REFUSAL OF PLANNING PERMISSION

APPLICATION NO. 2020/0154

Proposal Erection of first floor side and front extensions to dwelling

At 52 Garden House Close, Monk Bretton, Barnsley, S71 2ED

PROPOSED FRONT VIEW.

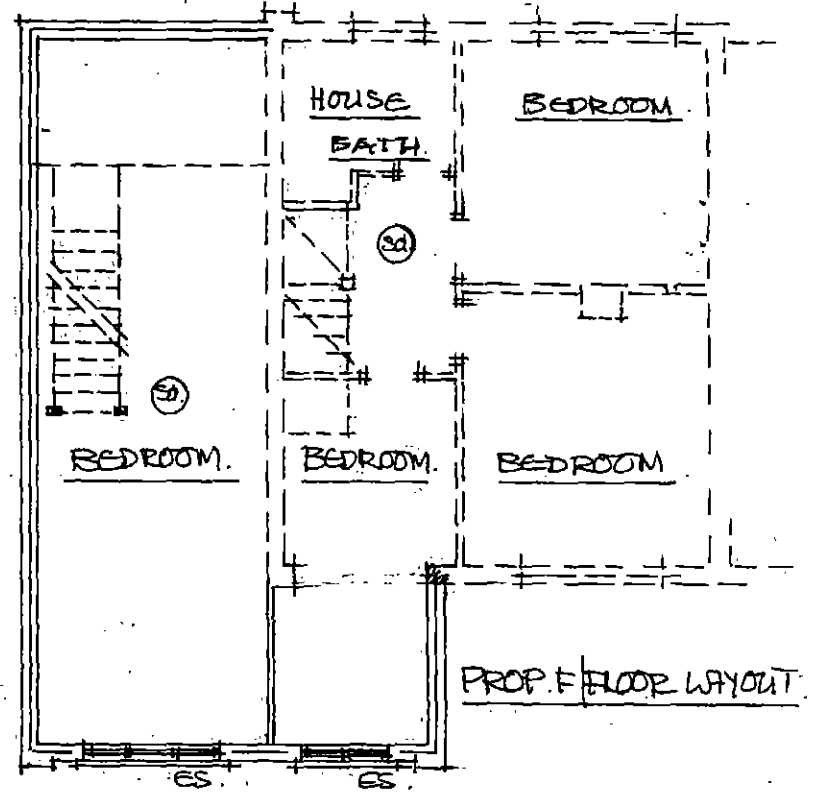
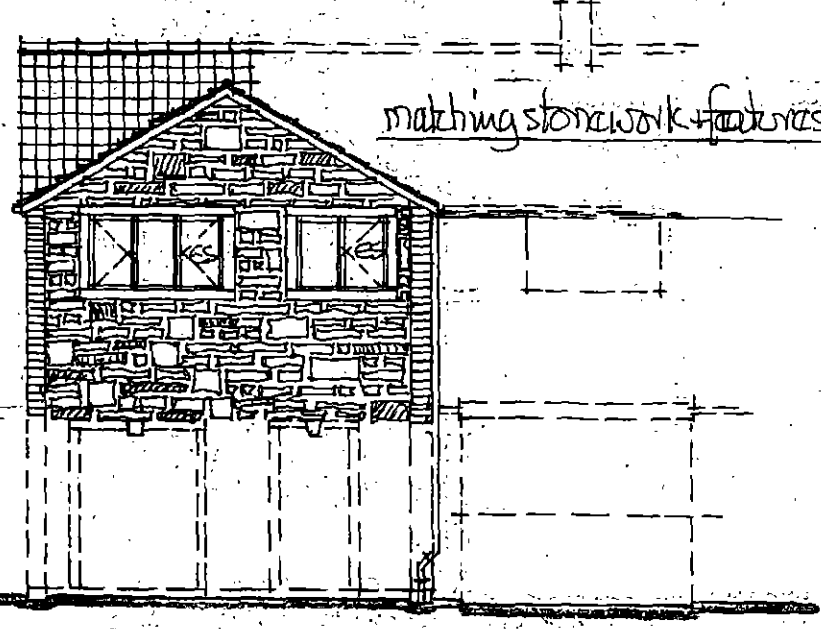
- 1 In the opinion of the Local Planning Authority the proposals would detract from the appearance of the host dwelling and the wider street scene by appearing as intrusive and unsympathetic addition. As a result the proposal is contrary to Local Plan Policy GD1 'General Development' and Council's Supplementary Planning Document (SPD): House Extensions and Other Domestic Alterations, in particular paragraphs 8.6-8.10 on Front Extensions.
